Re: Hagstrom Residence Critical Areas Report, Response to 2nd Peer Review Comments

The Watershed Company Reference Number: 160735

This letter represents our responses to the concerns and recommendations provided by the City's Peer Reviewer related to the recently revised mitigation plan and Critical Areas Report for your property located at 7428 SE 71st Street in Mercer Island, Washington. The comments were provided in an August 21, 2017, letter from Environmental Science Associates (ESA) (*Hagstrom Review CAO17-004, Resubmittal*). ESA's comments and recommendations are listed in italics below. Our response to the comments follow in standard font.

## DRAINAGE PLAN

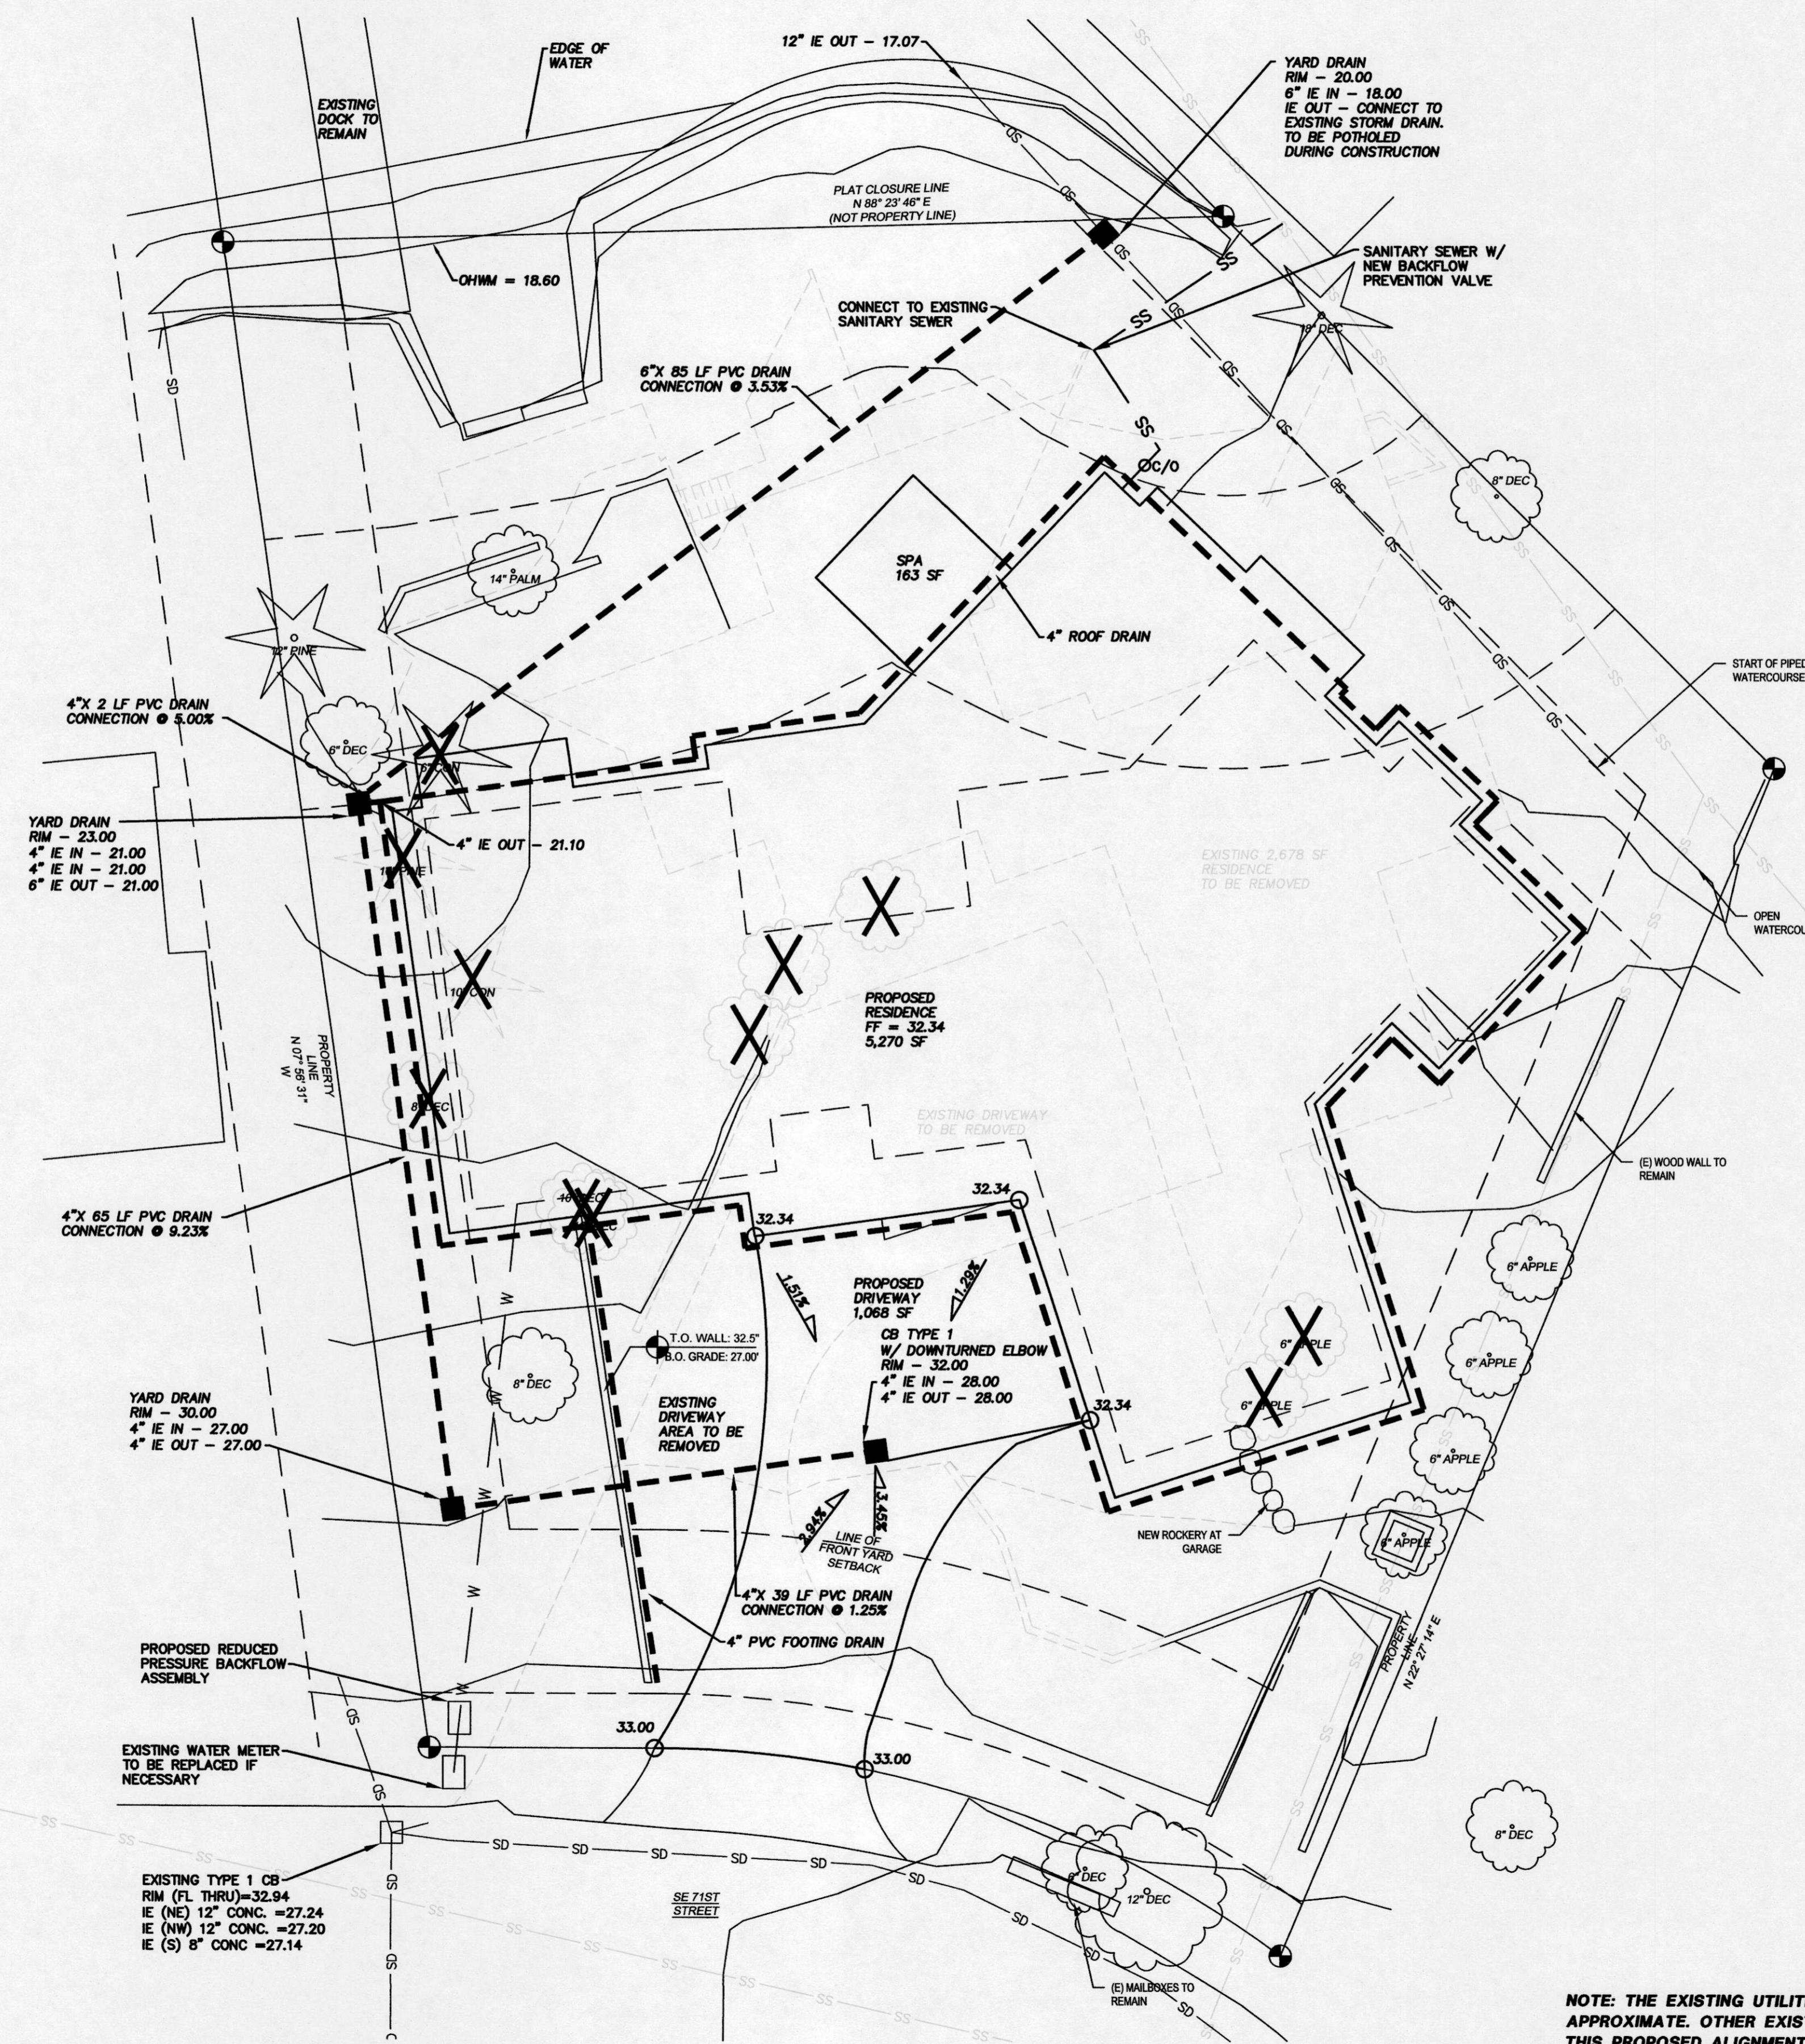
In addition to the recommendations above, we also recommend that the CAS be revised to include a discussion of the proposed storm drain catch basins and conveyance located within the reduced piped watercourse buffers and discharging to the piped segment of Watercourse A immediately above Lake Washington (per Engineering Drainage Plan [Eastside Consulting Inc., June 2017] provided by the City). While new utility facilities (including drainage conveyance and outfalls) may be allowed by MICC 19.07.030(7) (New Utility Facilities), the City requires mitigation and use of best management practices to the greatest extent reasonably feasible so there is no net loss in critical area functions. We recommend that the applicant be required to address potential impacts from proposed drainage facilities, and to provide mitigation consistent with MICC 19.07.030(7). Based on our review of submittal materials, we recommend options focused on reducing the amount of runoff from pollution generating impervious surfaces (the driveway), and/or providing basic water quality treatment for runoff. Potential options include the use of pervious materials for the driveway, or providing a vegetated bioswale in the conveyance flow path.

The purpose, necessity, functionality, and code compliance regarding the proposed conveyance feature have been addressed in the revised CAS. A vegetated bioswale has been added to the mitigation plan. The bioswale has been designed to treat 99% of the runoff volume from the adjacent roof and driveway. Design and specifications are provided in the CAS and Mitigation Plan.

SHEET NUMBER:  
W3 OF 7

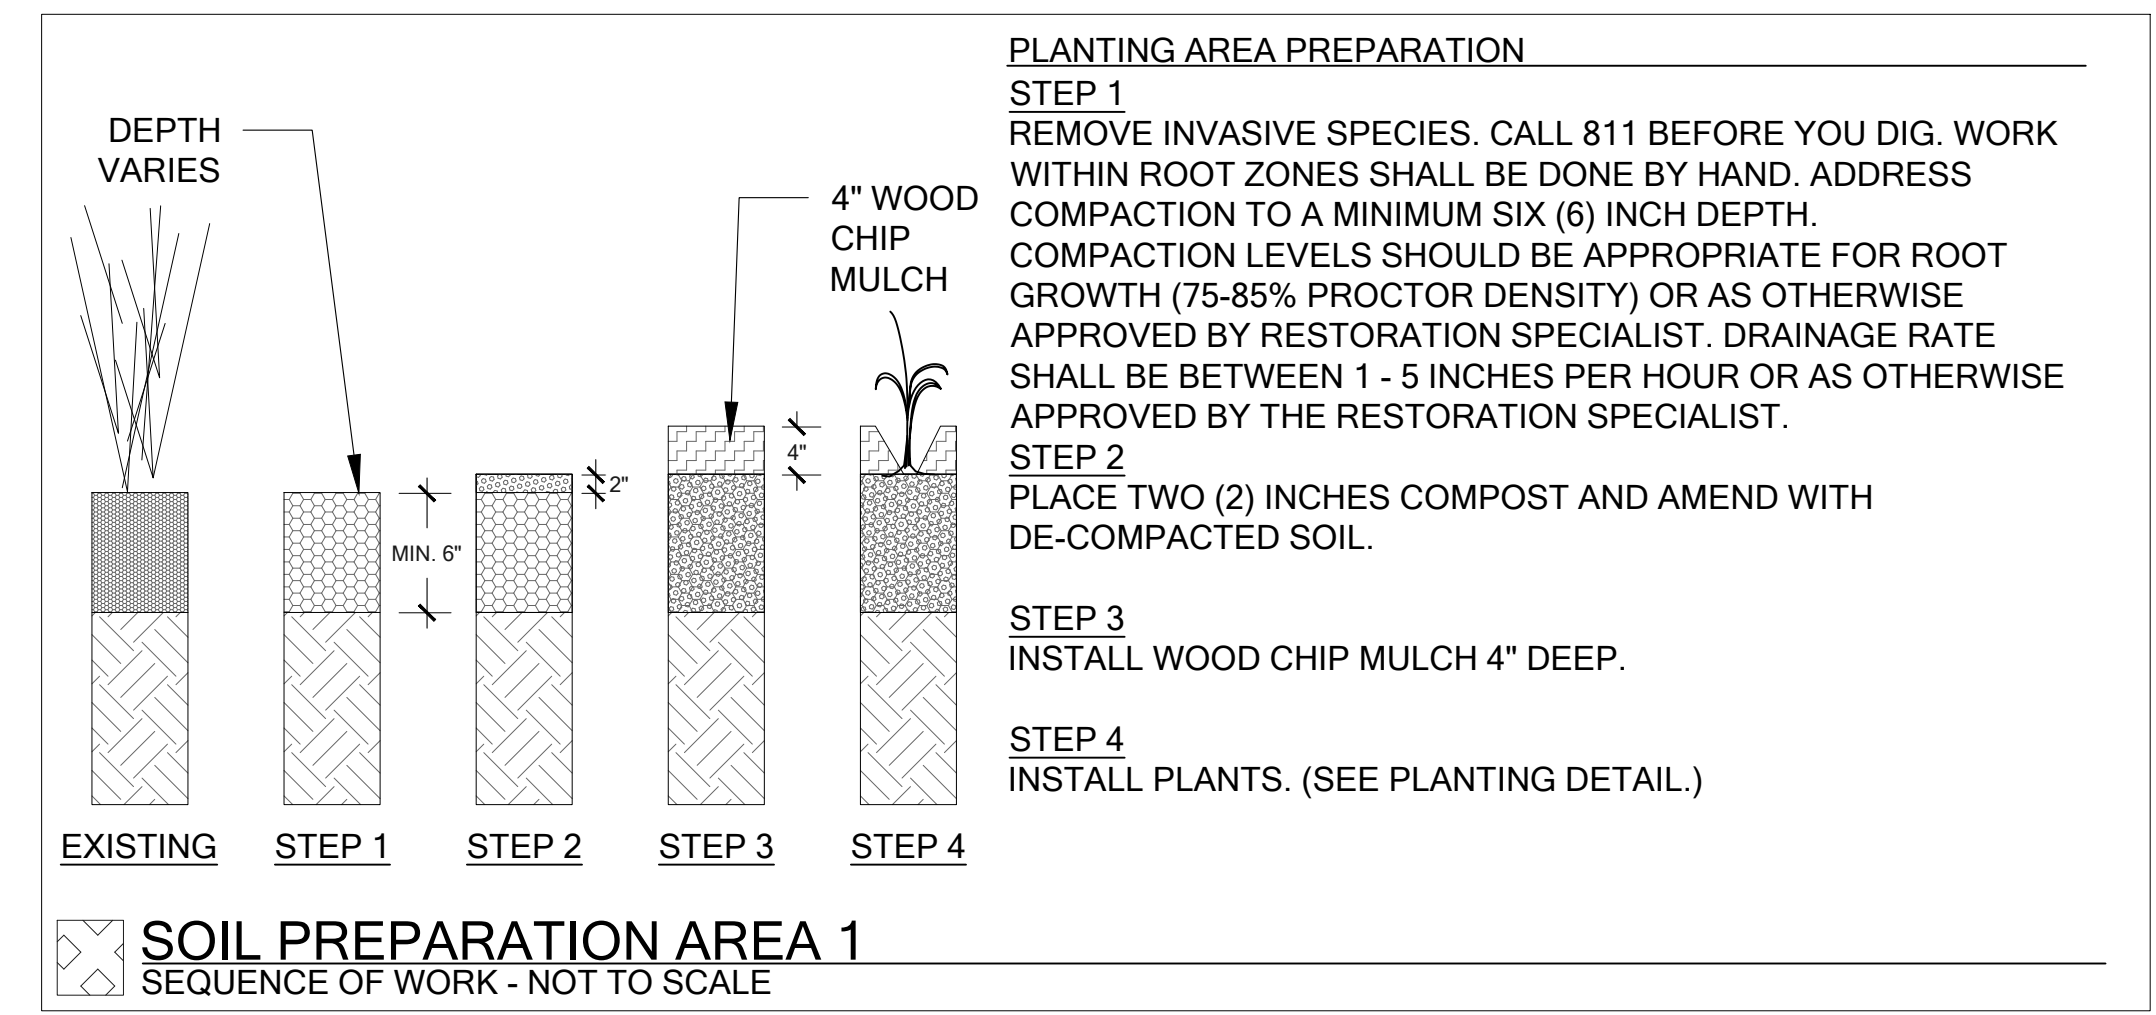
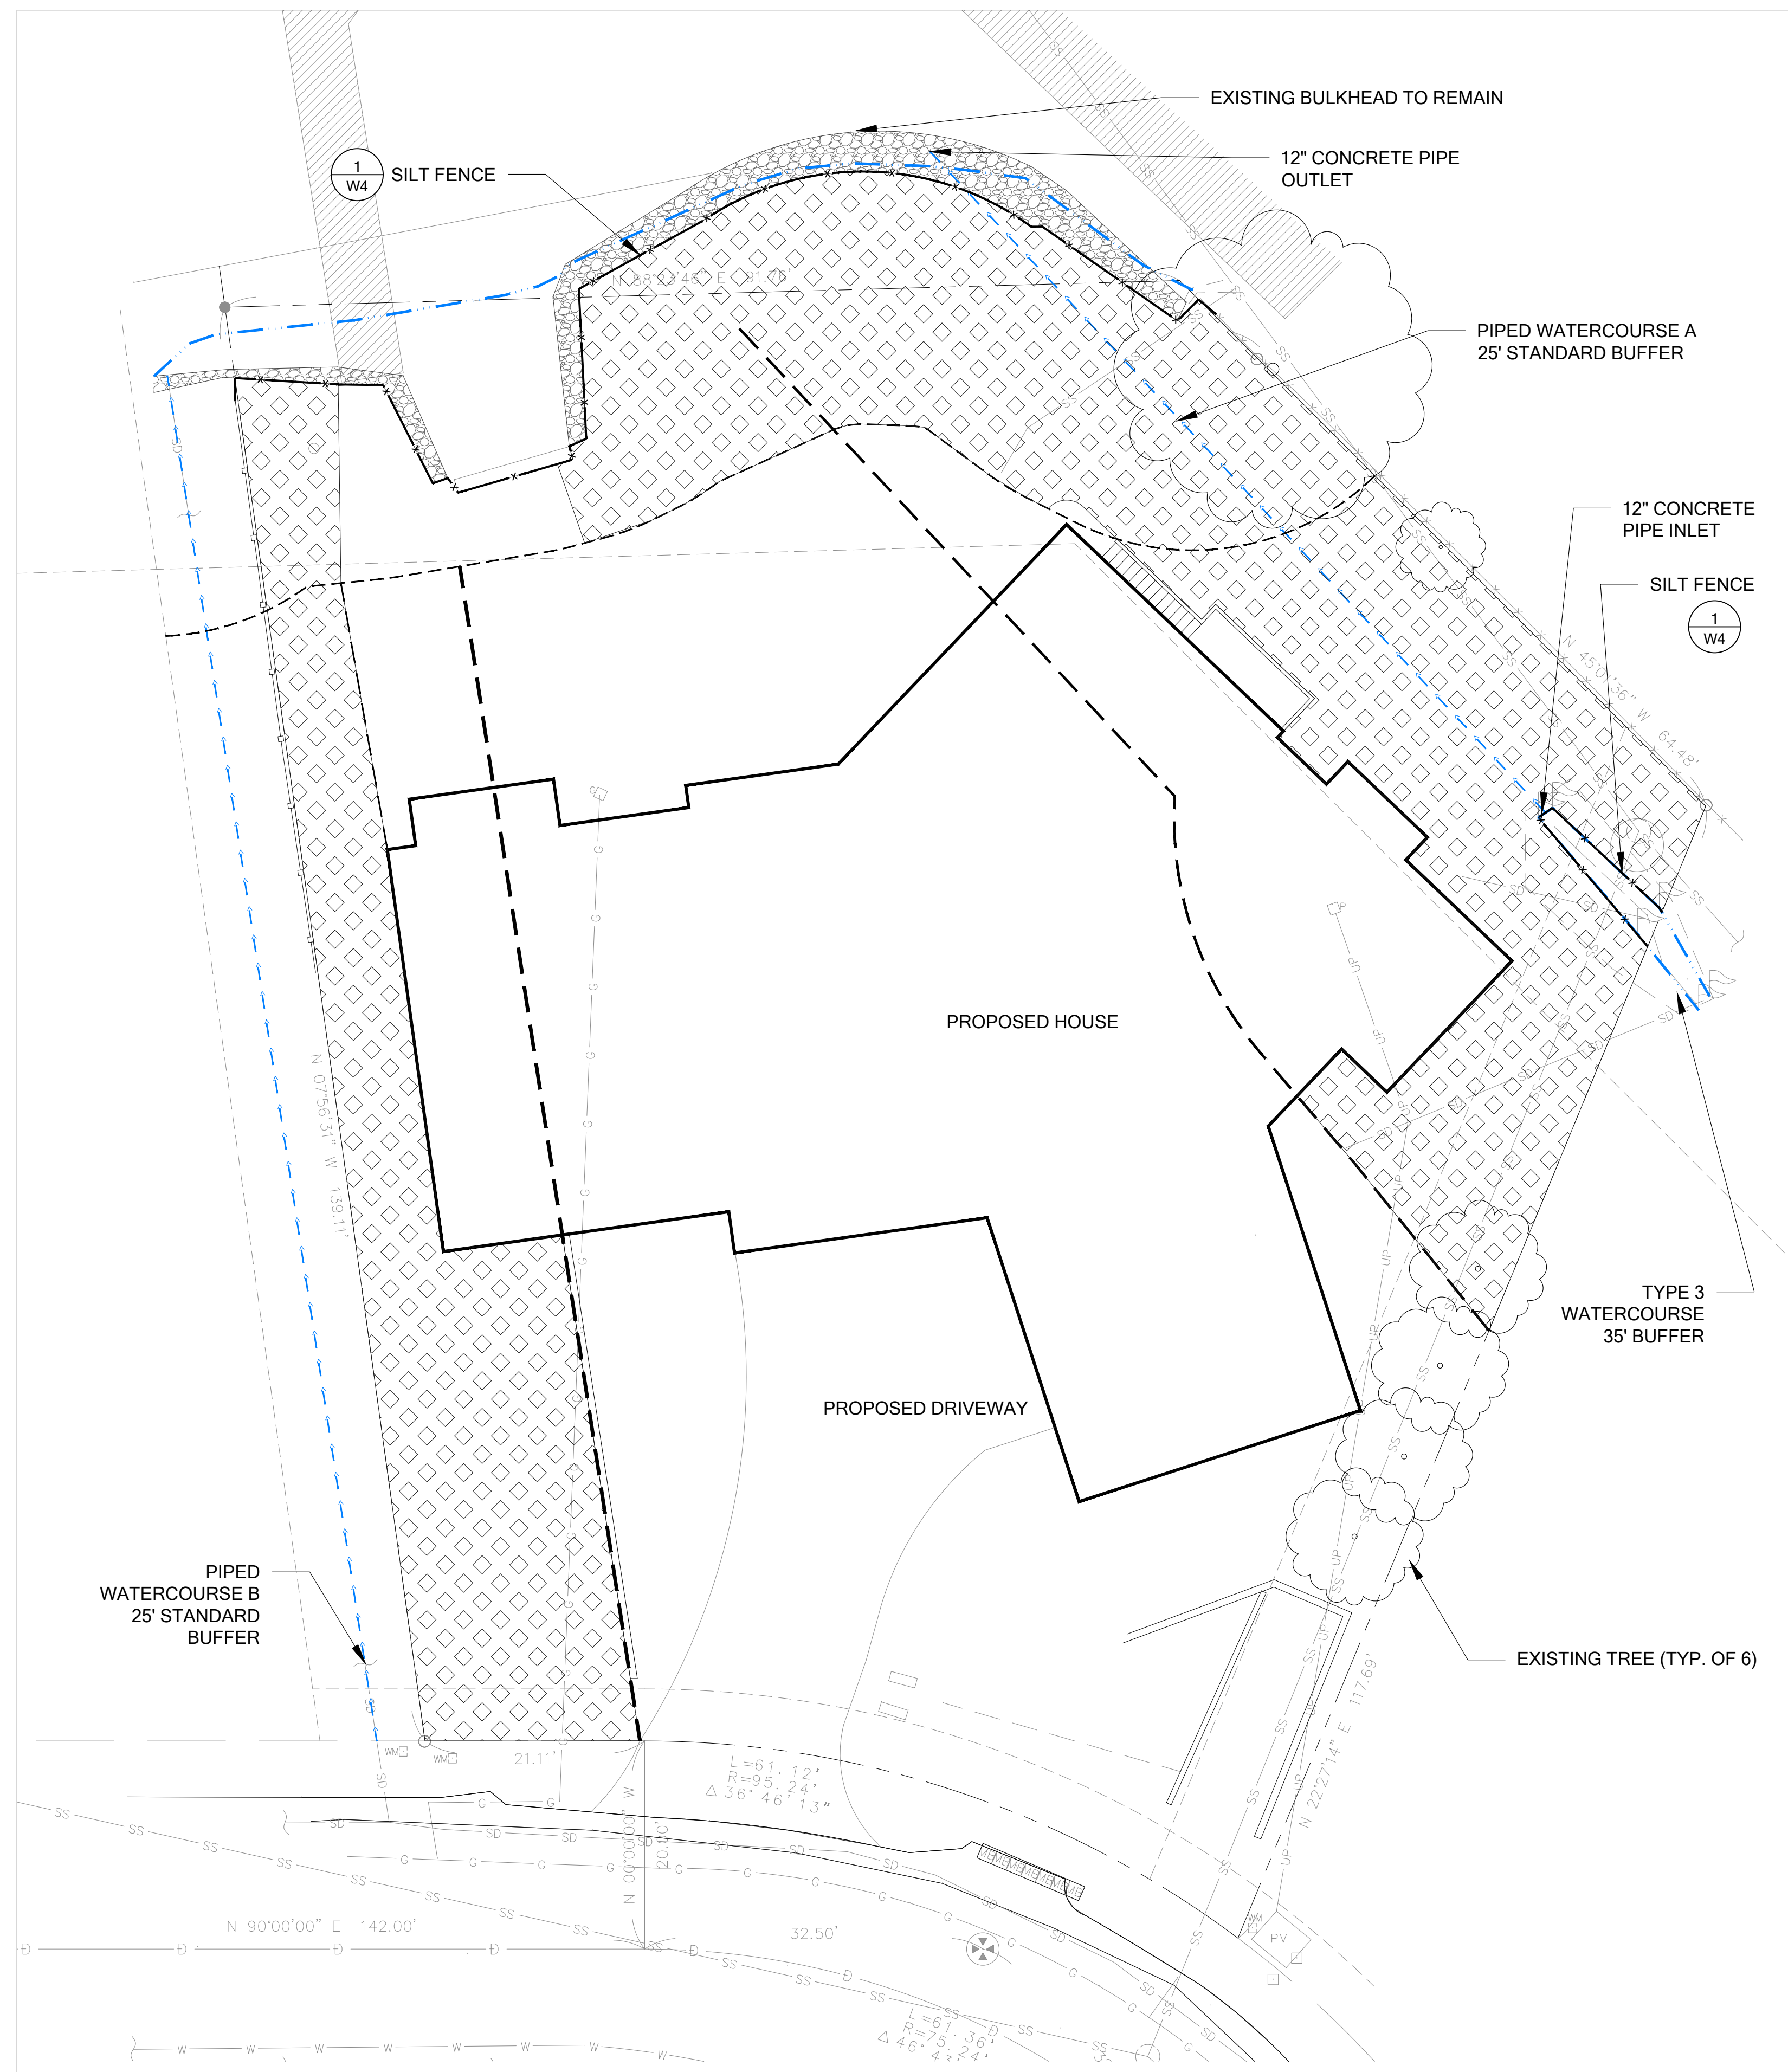
Discussion in the Comment Response memo provides adequate explanation and justification for not including Watercourse A impact area quantities. However, we recommend that some of the explanation from the memo be added to the CAS to better clarify proposed mitigation, such as '...the applicant is utilizing this provision [MICC 19.07.030.A.10] for the entire Watercourse A buffer for simplicity.' Also, we recommend that an asterisk be added to 'N/A' under reduction area for Watercourse A, and Shoreline Buffer, in Table 1 of the CAS that explains why there is no reduction area for those features for clarification purposes.

In addition, the Comment Response memo provides different quantities from those provided in the CAS for both the net decrease in impervious surface (173 sf), and enhancement area (1,643) within the Watercourse A buffer. It appears the mitigation plan has been updated to reflect these new quantities; we recommend that the CAS be updated to reflect these changes as well.

The additional discussions requested have been added to the CAS in Section 4.1 and Table 1. The CAS and Mitigation Plans both depict the same decrease in impervious surface (173 sf) and enhancement area (1,643 sf) within the Watercourse A buffer.
